Case Officer: Rebekah Morgan

Recommendation: Approve

Applicant: Morley Stores

Proposal: Discharge of conditions 4 (means of access), 5 (turning area details), 6 (detailed scheme for the surface water and foul sewage drainage) and 9 (Construction Environment Management Plan) of 20/02139/F

Drawn By:	RS	Client	Markbank Construction Ltd.
Chkd By:	WRA	Project	Proposed Redevelopment, Morley Site, Arkwright Road, Bicester
Scale @A3:	1:500	Title	Impermeable Area Plan
Date:	08.07.2021		
Status:	TENDER		
Project No.:	23200	Drawing No:	E13
		Rev:	B

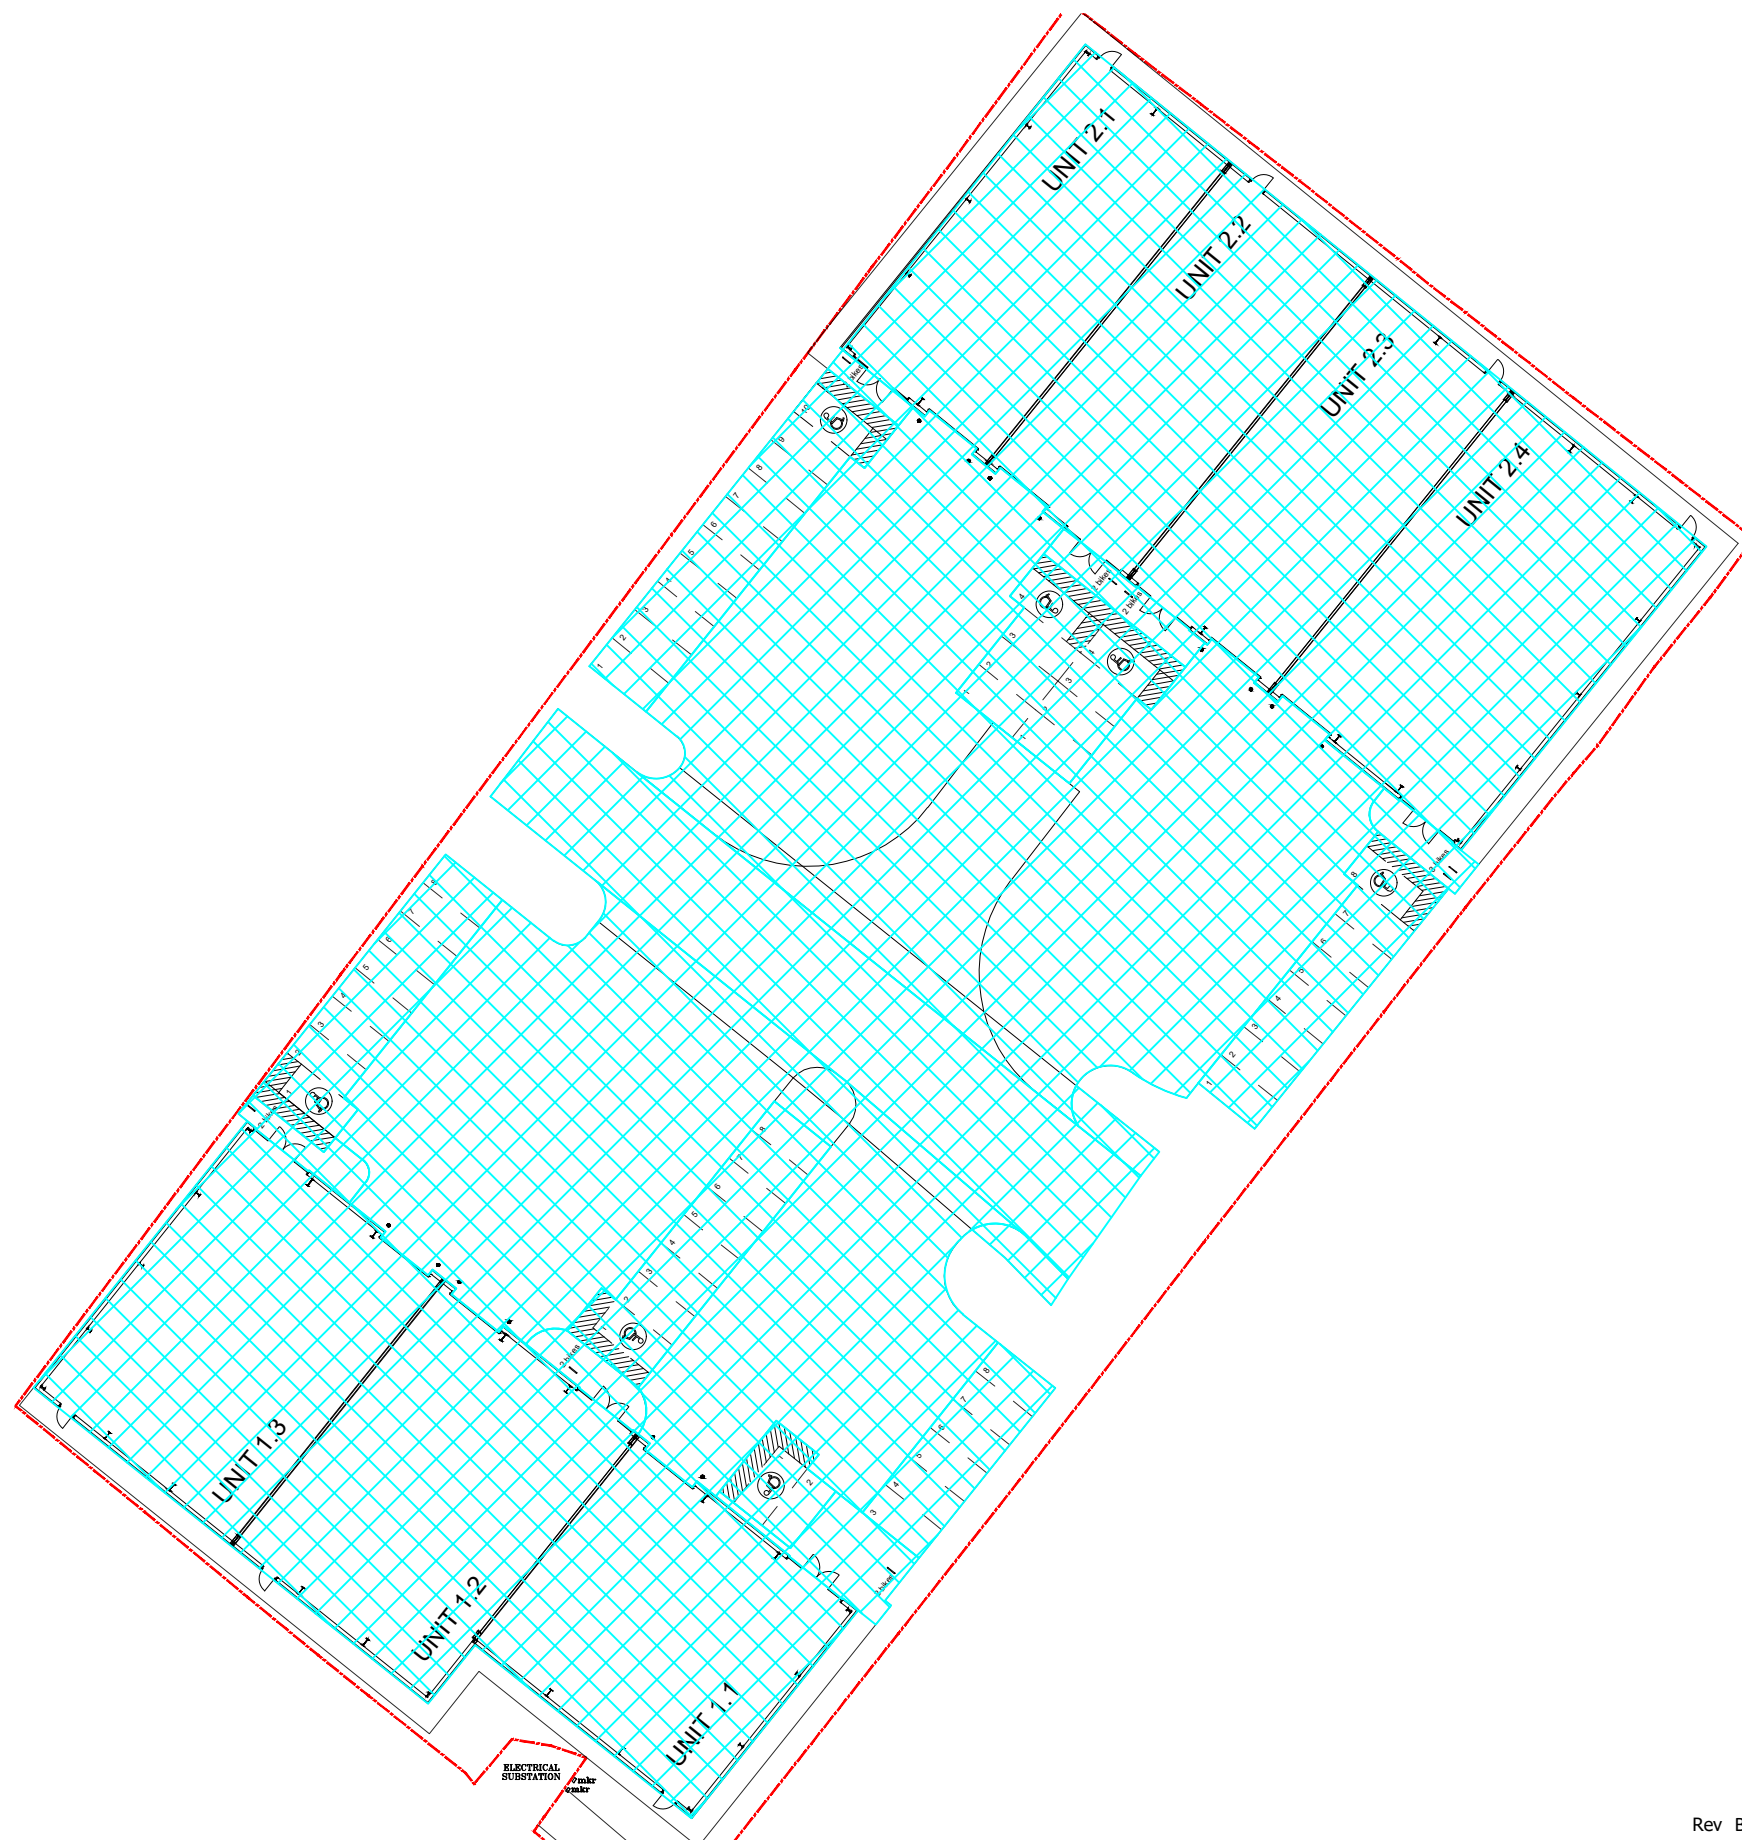
- 5.2. Condition 5 – The applicant has demonstrated a layout that provides 49 parking spaces and sufficient space for the manoeuvring of an articulated vehicle to enter/exit the site. OCC Highway officers confirmed the details are acceptable.

The proposed turning area specification and car parking details are acceptable and the condition is therefore recommended to be discharged.

<table><tr><td>Drawn By:</td><td>RS</td><td>Client:</td><td>Markbank Construction Ltd</td></tr><tr><td>Scale @ A0:</td><td>1:200</td><td>Title:</td><td>Proposed Drainage Layout</td></tr></table>

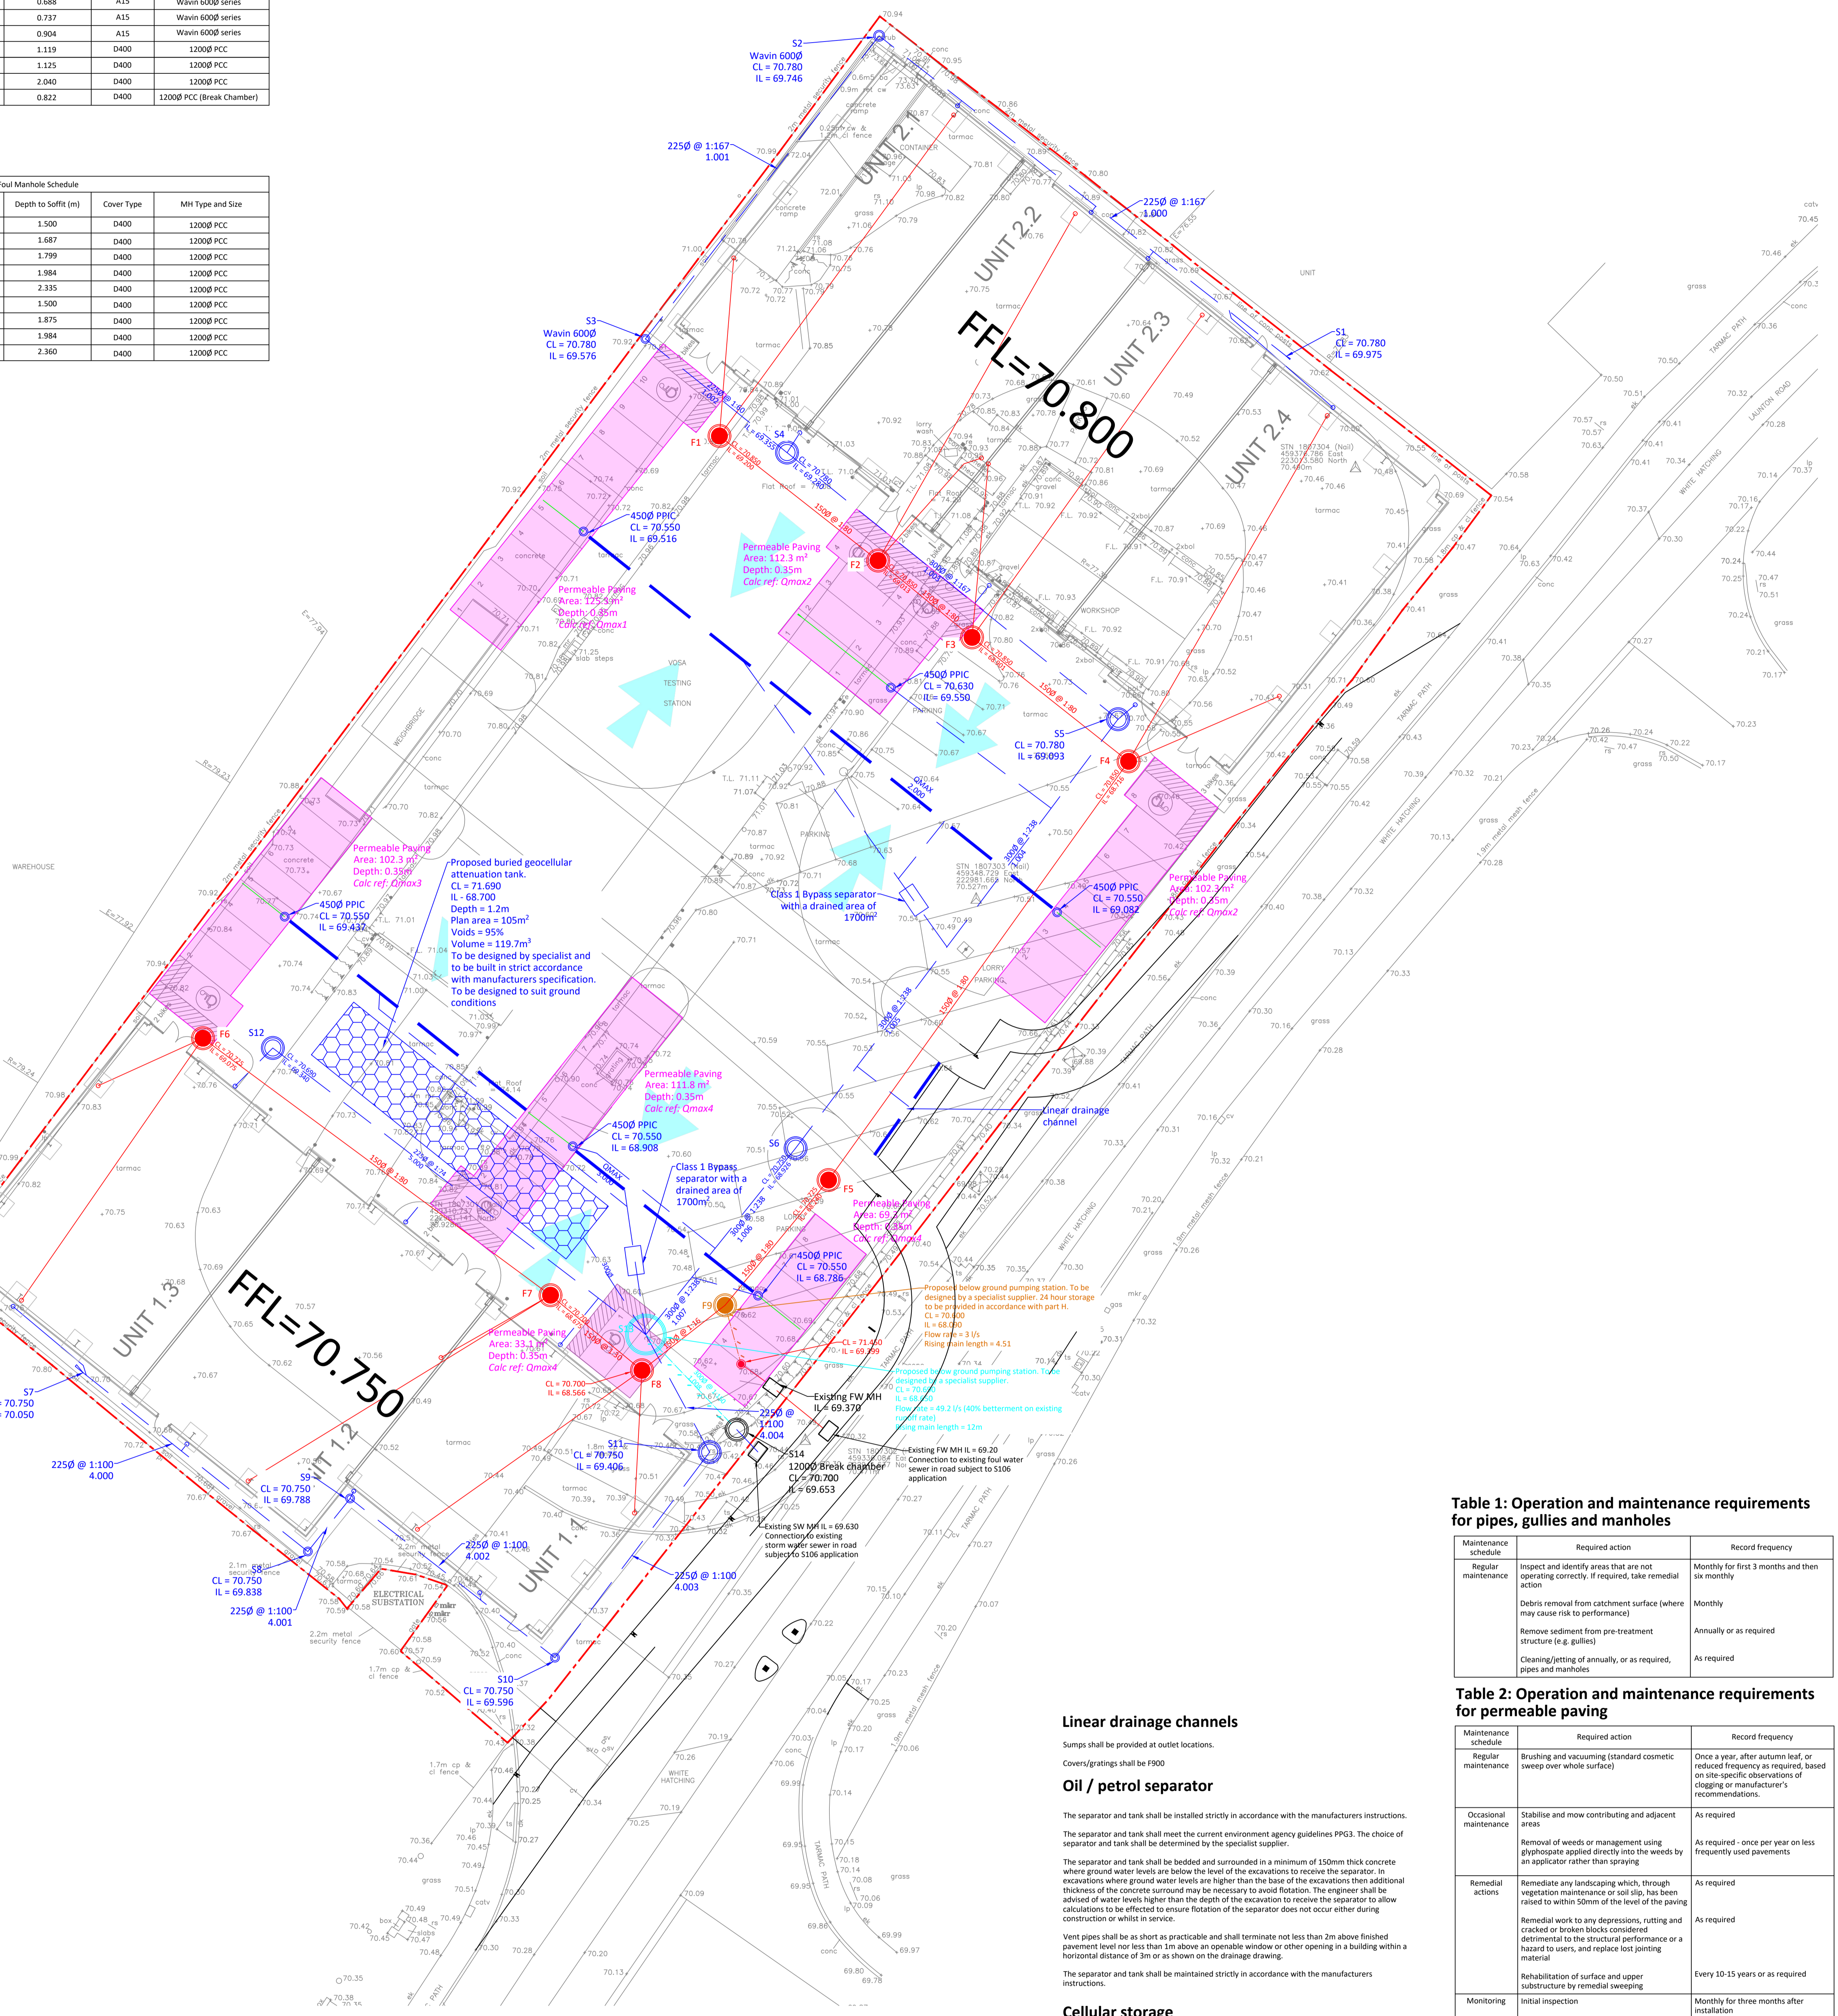
- 5.3. Condition 6 – There has been an ongoing dialogue with the LLFA regarding the proposals. Amended and additional information has been submitted in response to the initial objections that were raised.

The LLFA is now satisfied with the submitted drainage drawings and calculations.

CDC land drainage have advised the foul and surface water drainage strategies are acceptable in principle and the applicant has provided a copy of the relevant consent from Thames Water to connect indirectly to the sewer network.

Overall, the proposed drainage details are considered acceptable and the condition is recommended to be discharged.
